From: William Watkins williamwatkins@arpassociates.co.uk
Subject: FW: ODL/01 - KC comments for Condition 10 Remediation Strategy - Land at St Lukes Bierley Marsh
Date: 22 July 2025 at 09:57
To: npjacques@nj-architects.co.uk

From: William Watkins
Sent: Thursday 17 July, 2025 11:03am
To: Lauren Simpson Owens Developments
<lauren.simpson@owensdevelopments.co.uk>
Cc: Mike Harper <mikeharper@arpassociates.co.uk>
Subject: RE: ODL/01 - KC comments for Condition 10 Remediation Strategy - Land at St Lukes Bierley Marsh

SITE INVESTIGATION PLAN

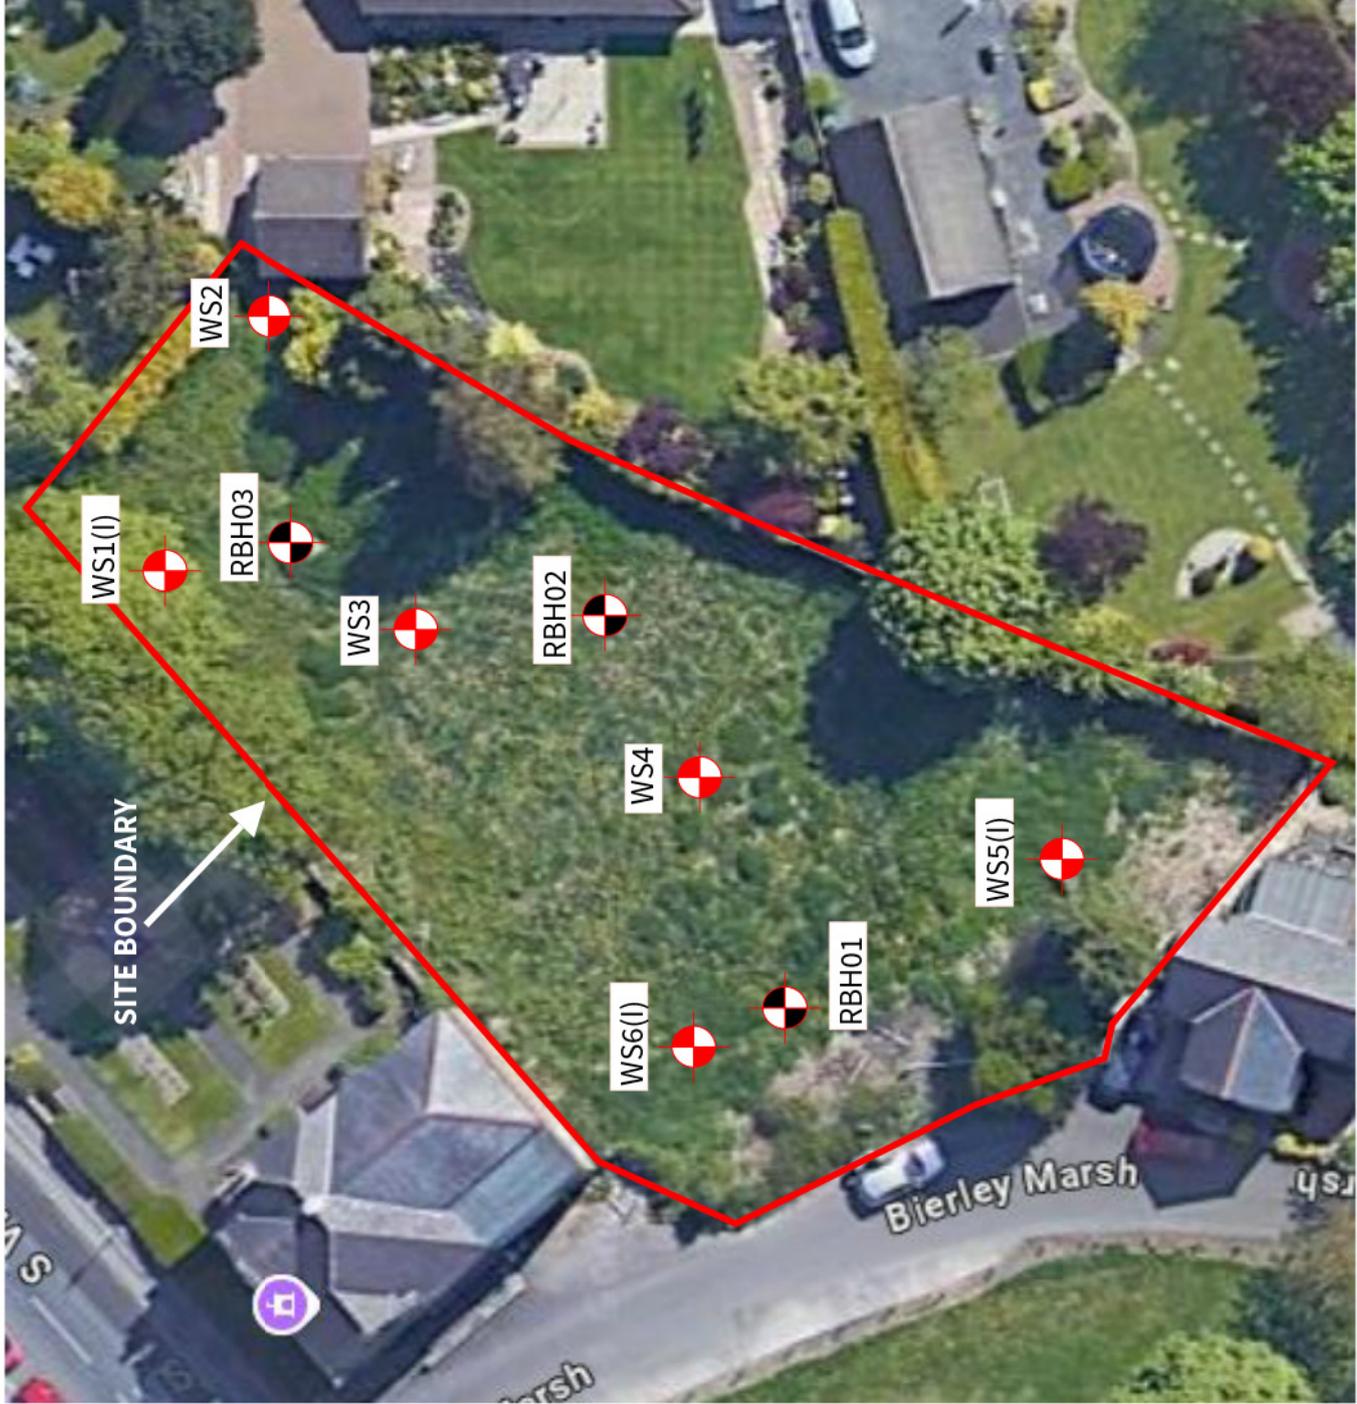
- **Confirmation via additional testing that all contaminated topsoil has been removed from site.**
 - ARP consider validation of topsoil removal will come under a separate condition that deals with Remediation Verification not Condition 10 for approval of the Remediation Strategy.

- **Further testing on clay soils to confirm the vertical extent of hotspots to be proven.**
 - Four clay soils samples were taken, with three around the identified hot spots at HP/01, HP/03 & HP/04 which were found to have all determinants below screening values.

- **Clarification as to whether this extends to the made ground topsoil at WS6.**
 - The latest supplementary sampling letter Ref ODL/01/L4WWREV2: does not extend to the made ground topsoil at WS6 and is to be dealt with as set out in ARP's Contamination Remediation Statement Ref: ODL/01rem1, Dated: 16TH OF September 2024.

- Further, per ARP'S Remediation Strategy: Validation will require the excavation bases and faces to be inspected and tested at 25m spacing to confirm contamination status.

- Therefore, ARP consider that further testing will come under a separate condition that deals with Remediation Verification not Condition 10 for approval of the Remediation Strategy.
